Application No: A/253/21/OUT
Site Address: Land between 32 Downs Way and 2 Ambersham Crescent Angmering BN16 1AB
Description of works: Outline planning application with all matters reserved for the erection of 1 No bungalow dwelling with off street parking and private amenity space.

Thank you for your internet representation made on 21st January 2022 which has been recorded as an objection with the comments as follows:

OWPC43599

Indicative Plans and Elevations

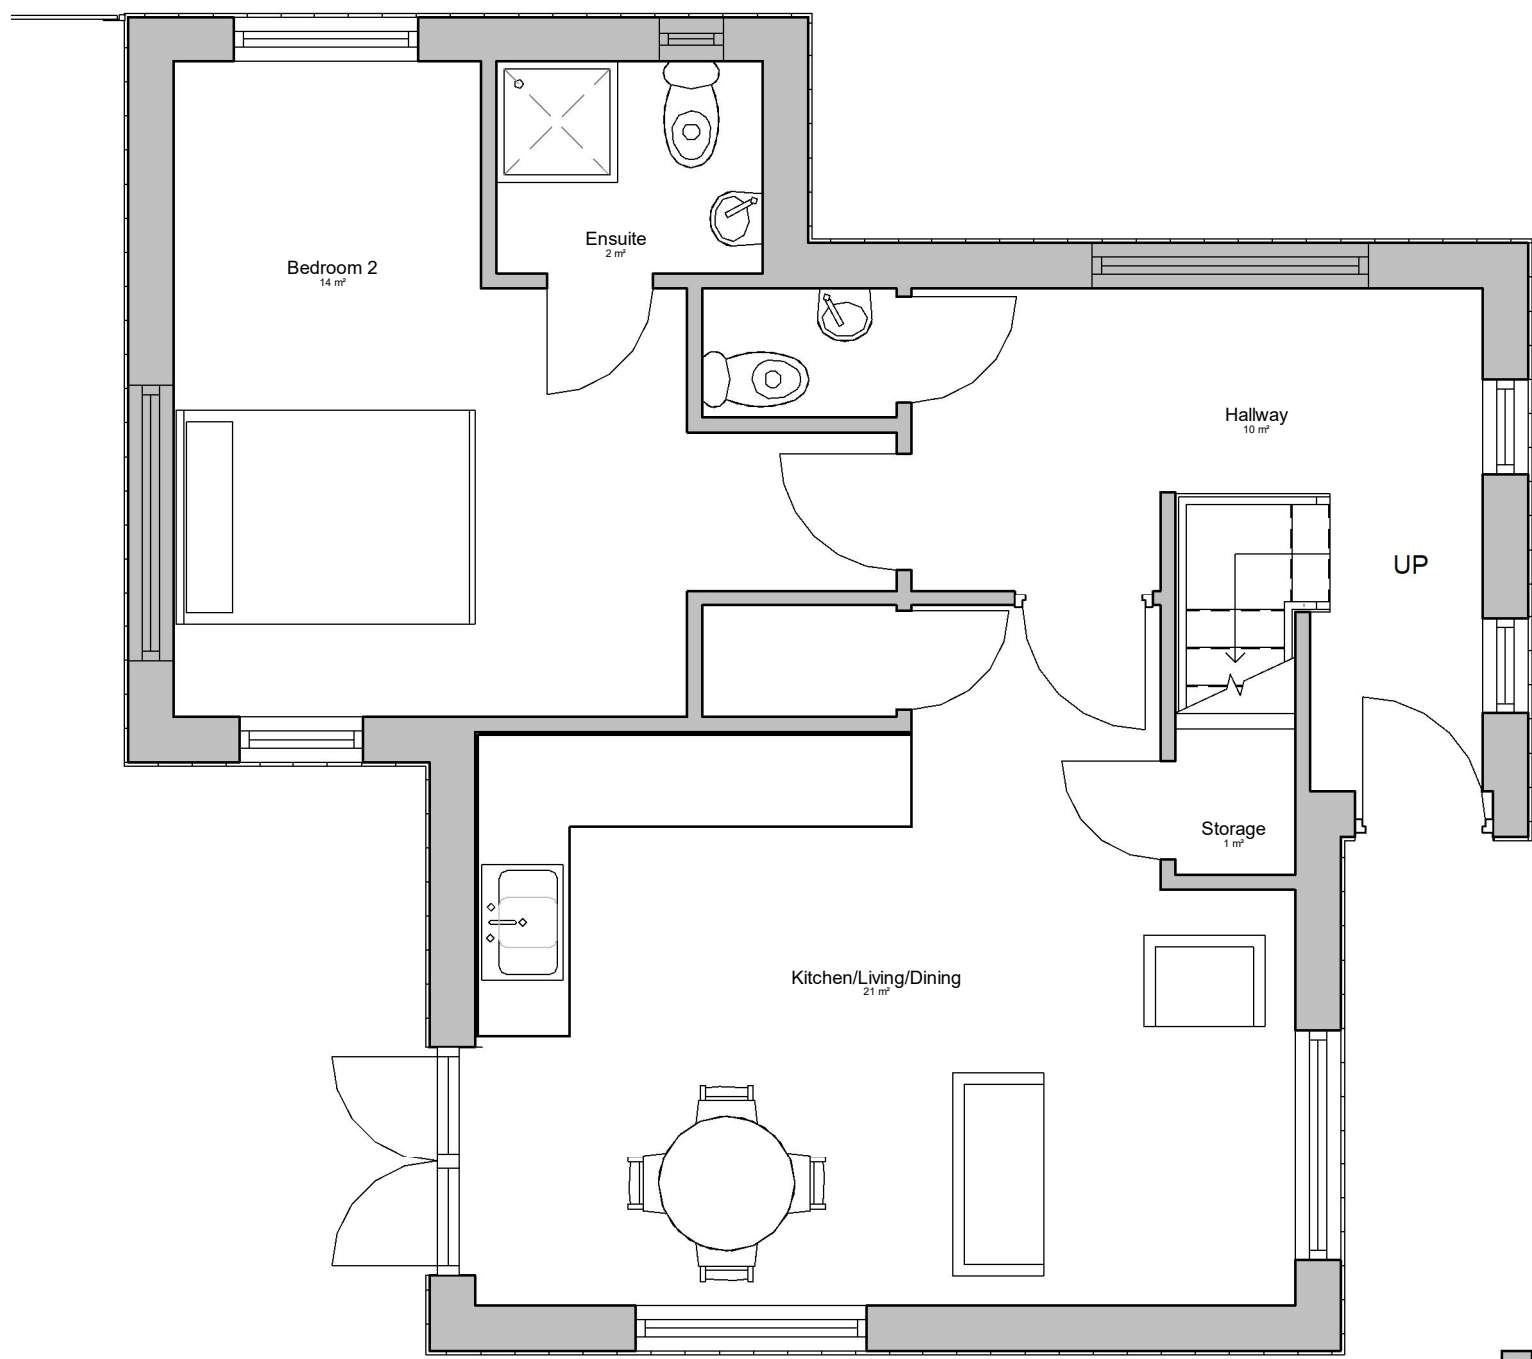
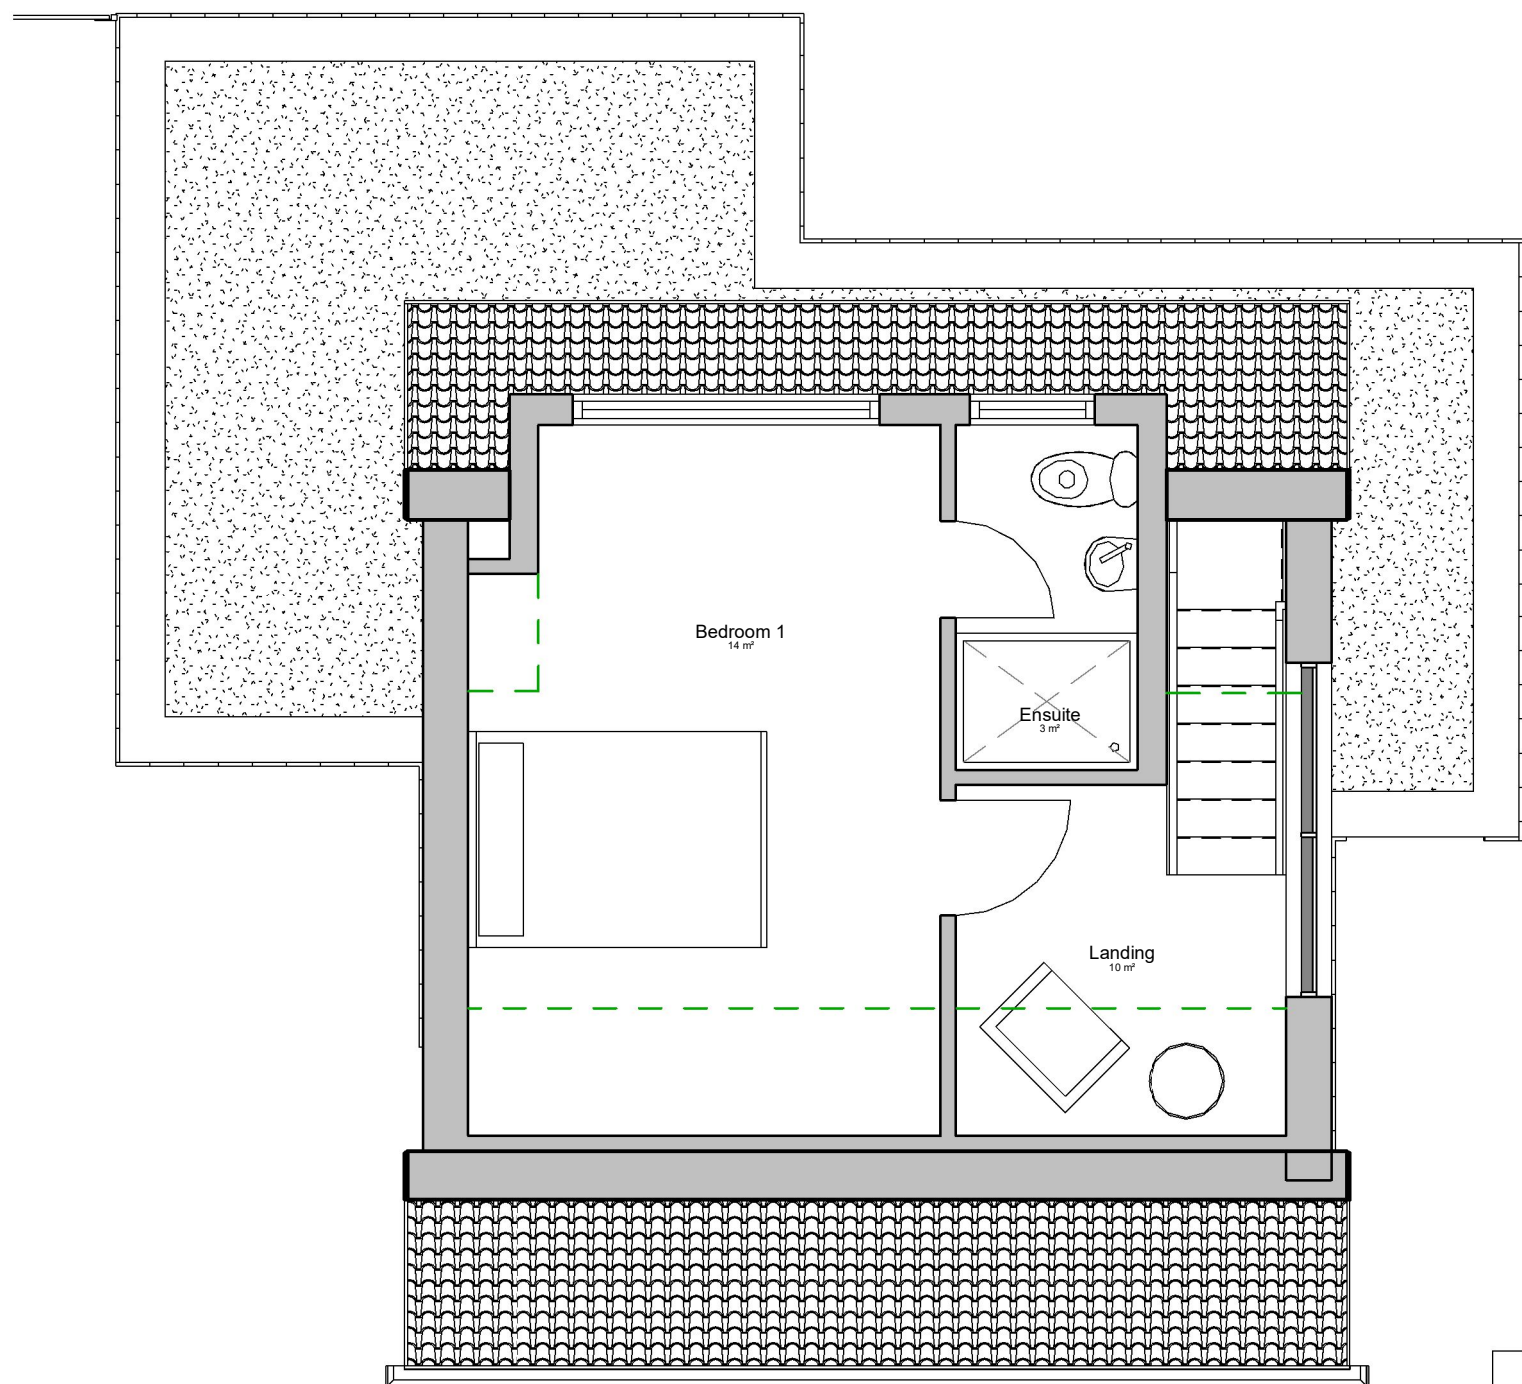
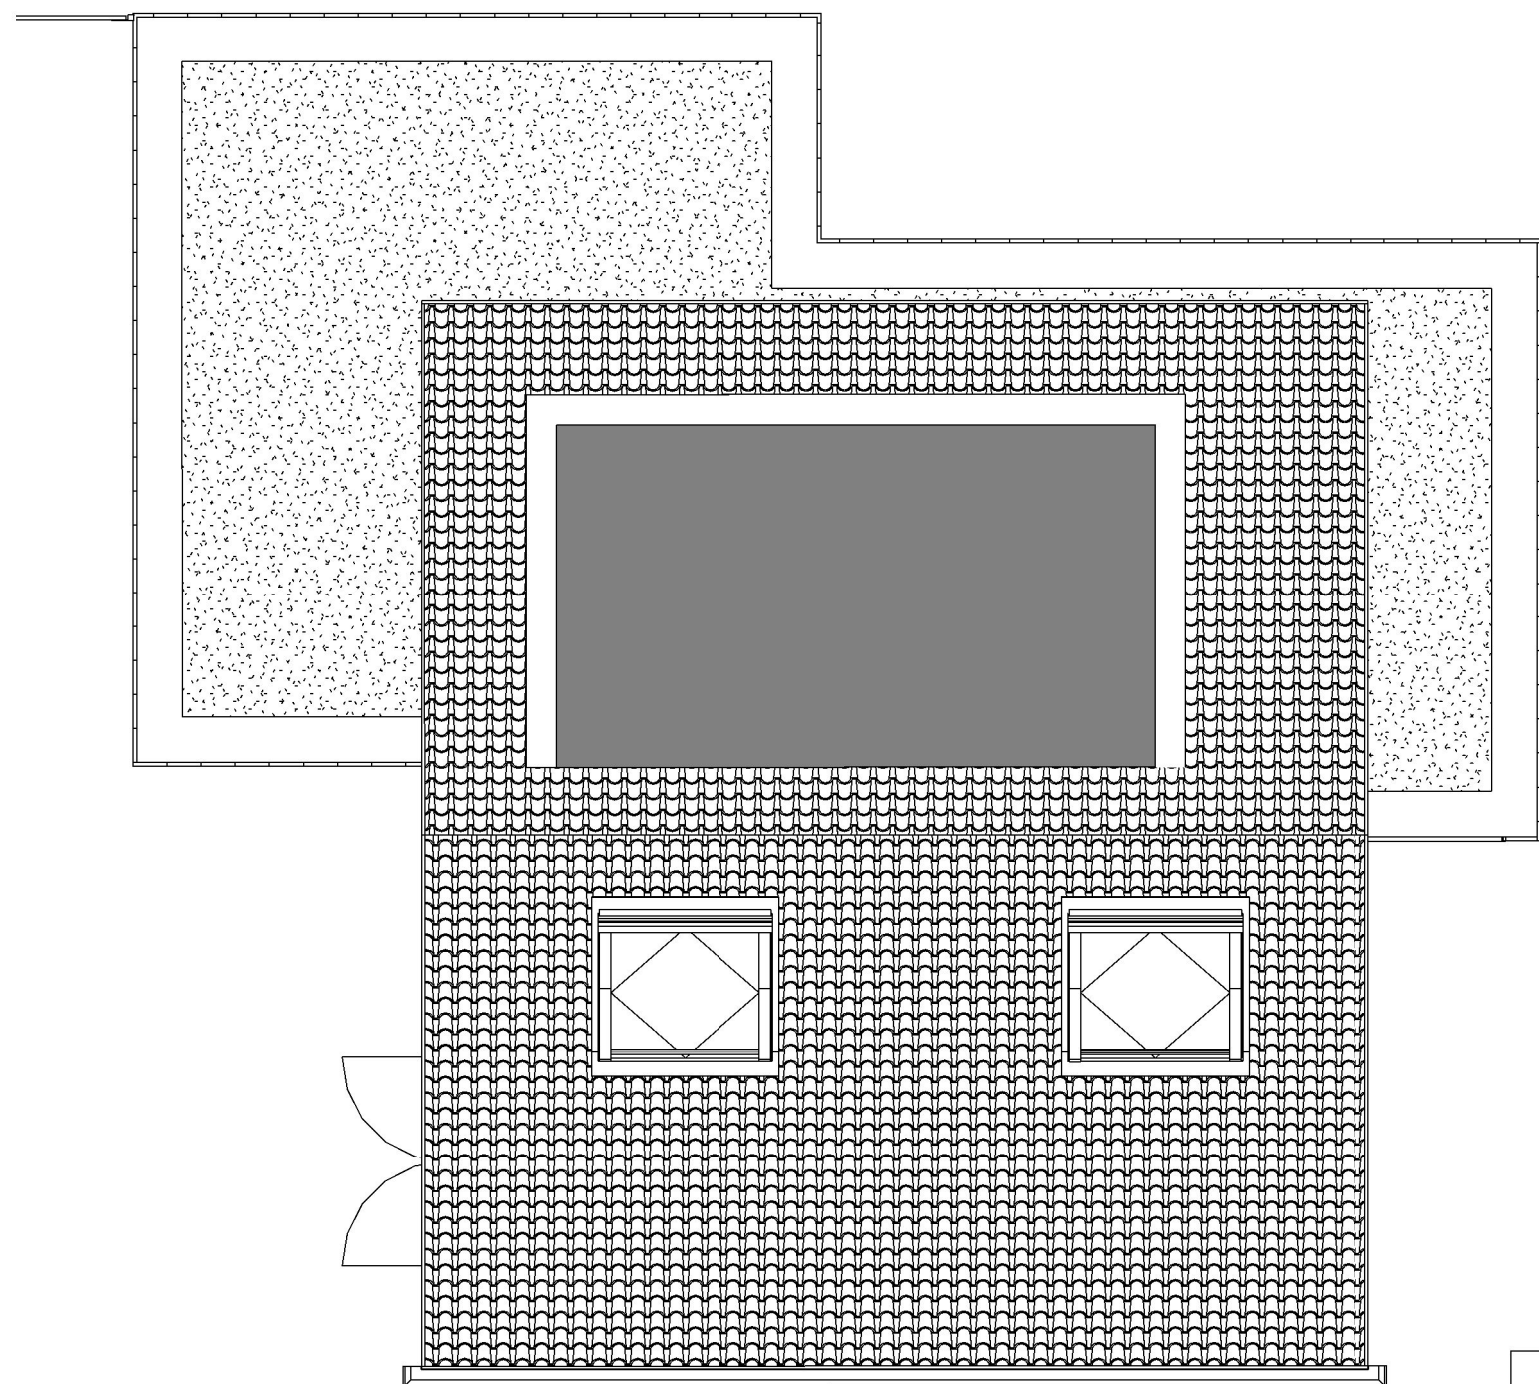
The loss of public greenspaces, no matter the size, should always be avoided where possible. The plot is small, home to a large tree, a footpath dissecting the site and a public seat. It is difficult to imagine how such a small site could support and sustain a property which indicative drawings suggest to be quite sizeable.
